**Consultation Response from KC,
Highways Development Management**

2021/93847 Red Doles Building, Red Doles Lane, Huddersfield, HD2 1YF

Erection of building to store and charge mobility aids with 2 additional disabled parking spaces

**Date Responded:
27/10/2021**

PROPOSED PLAN 1:100

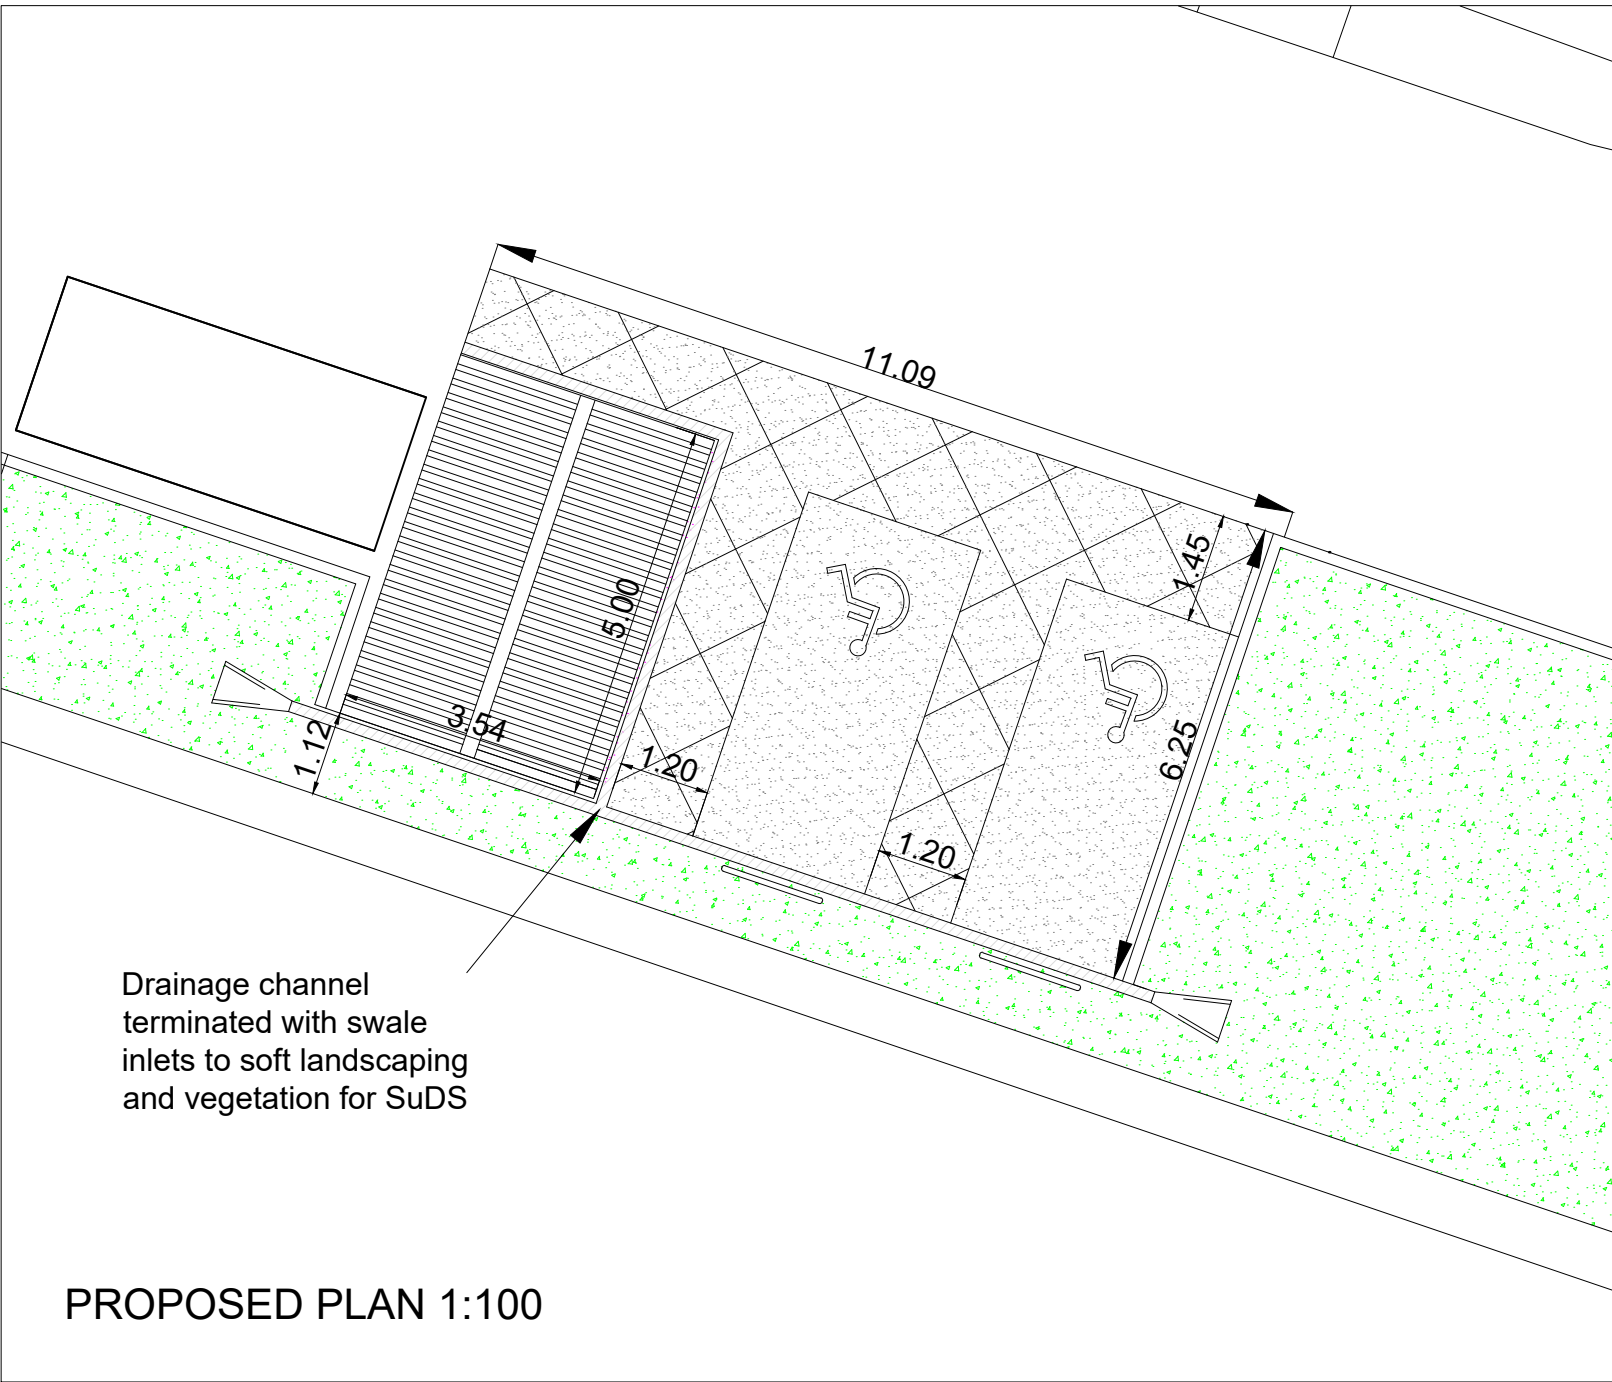
The disabled parking spaces have been presented with the correct dimensions of 2.4 x 4.8m with a 1.2m gap to the side and rear. The existing access from Red Doles Lane will be used for the additional spaces.

There is a sufficient distance to the rear of the parking spaces to allow a vehicle to manoeuvre.

Prior to the development being brought into use, the proposed disabled parking spaces hereby approved shall be laid out surfaced, marked out into bays, and drained in accordance with details that have previously been approved in writing by the Local Planning Authority.
